ALDINGBOURNE PARISH COUNCIL
Clerk – Mrs JKM Brown ACIS
100 Middleton Road
Middleton on Sea
PO22 6DL
01243 582667

28th November 2016

Re: Application for approval of Reserved Matters at Hook Lane, Westergate, Sussex, PO20 3TE (ADC reference AL/107/16/RES)

Aldingbourne Parish Council objects to the application for approval of the reserved matters and I write to provide a review of the most salient issues associated with the proposed residential development at Westergate Street, east of Hook Lane, Westergate, Sussex, PO20 3TE (the 'Applications Site'): 'Application for Reserved Matters application following Outline Planning Permission AL/39/13 for the demolition of Oakdene and all other structures within the site and the erection of 79 dwellings, public open space, children's play areas, landscaping, drainage measures, sub-station, pumping station and all other associated works.'

Drawing Title:
HOUSE TYPE
ASHWORTH (AFFORDABLE)
FLOOR PLANS

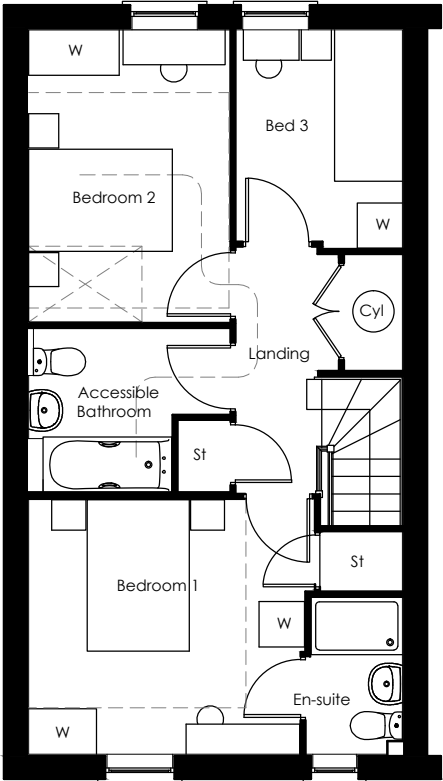
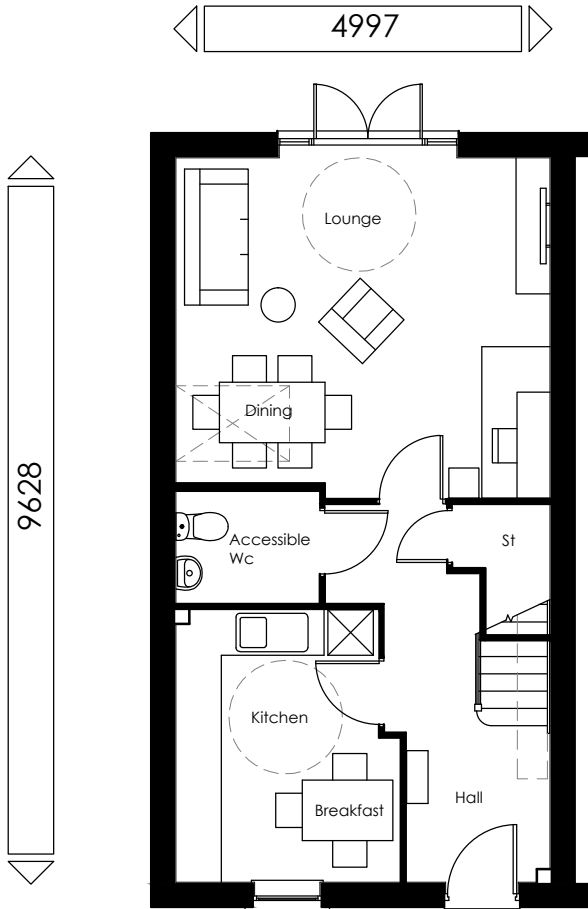
Policy D DM3 of the eALP sets out external space standards for residential development. As no schedule of accommodation appears to have been provided it is difficult to establish whether the standards have been met for all of the proposed dwellings. However, it is evident that the 'small semi-detached' dwellings proposed do not meet the required minimum standard of 65sqm. More information is needed but in any case, it is clear that the Proposed Development is contrary to eALP Policy D DM 3. The Design and Access Statement only refers to minimum depth standards' with no mention of the 'area' standards.
